WEST SUSSEX COUNTY COUNCIL CONSULTATION

TO:	Arun District Council FAO: Maria Tomalova
FROM:	WSCC - Highways Authority
DATE:	22 July 2020
LOCATION:	Former Royal Bay Residential Home, 86 Aldwick Road, Bognor Regis, PO21 2PE
SUBJECT:	BR/138/20/PL Temporary change of use from Care Home (C2) to temporary accommodation for seasonal agricultural workers for 12-month period.
DATE OF SITE VISIT:	N/A
RECOMMENDATION:	More Information
S106 CONTRIBUTION TOTAL:	N/A

PROPOSED GROUND FLOOR PLAN (1:200)

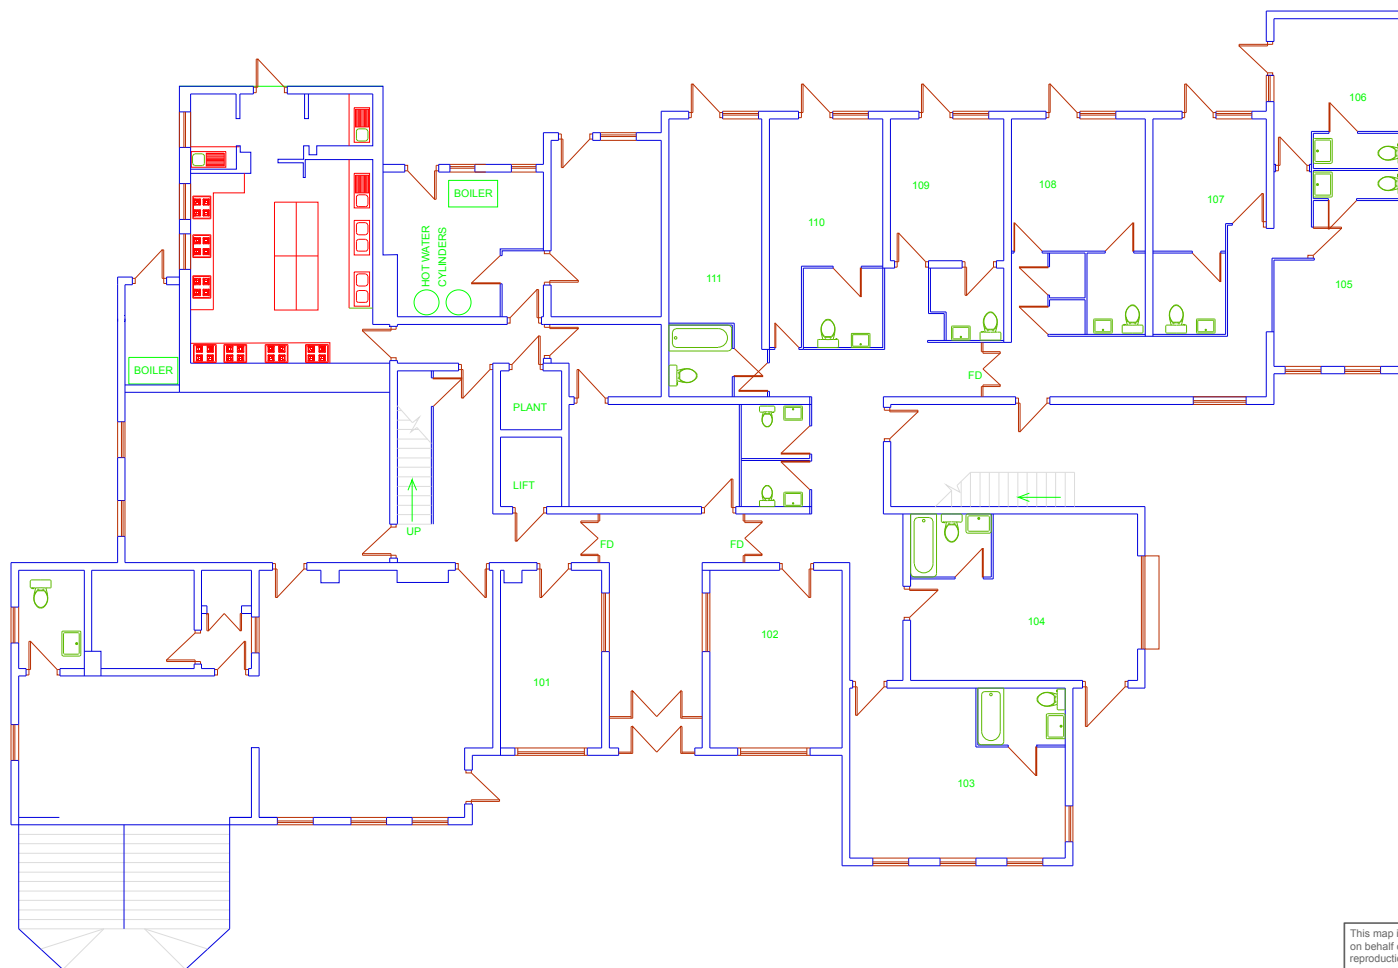
WSCC policy states that when an intensification of 50 or more movements per day is expected, a Stage 1 Road Safety Audit (RSA) is required. Depending on the information provided in return, the LHA reserves the right to request an RSA. The applicant should also produce a block plan, demonstrating parking layout. Demonstration of the ability for a minibus to park and turn on-site would be beneficial.
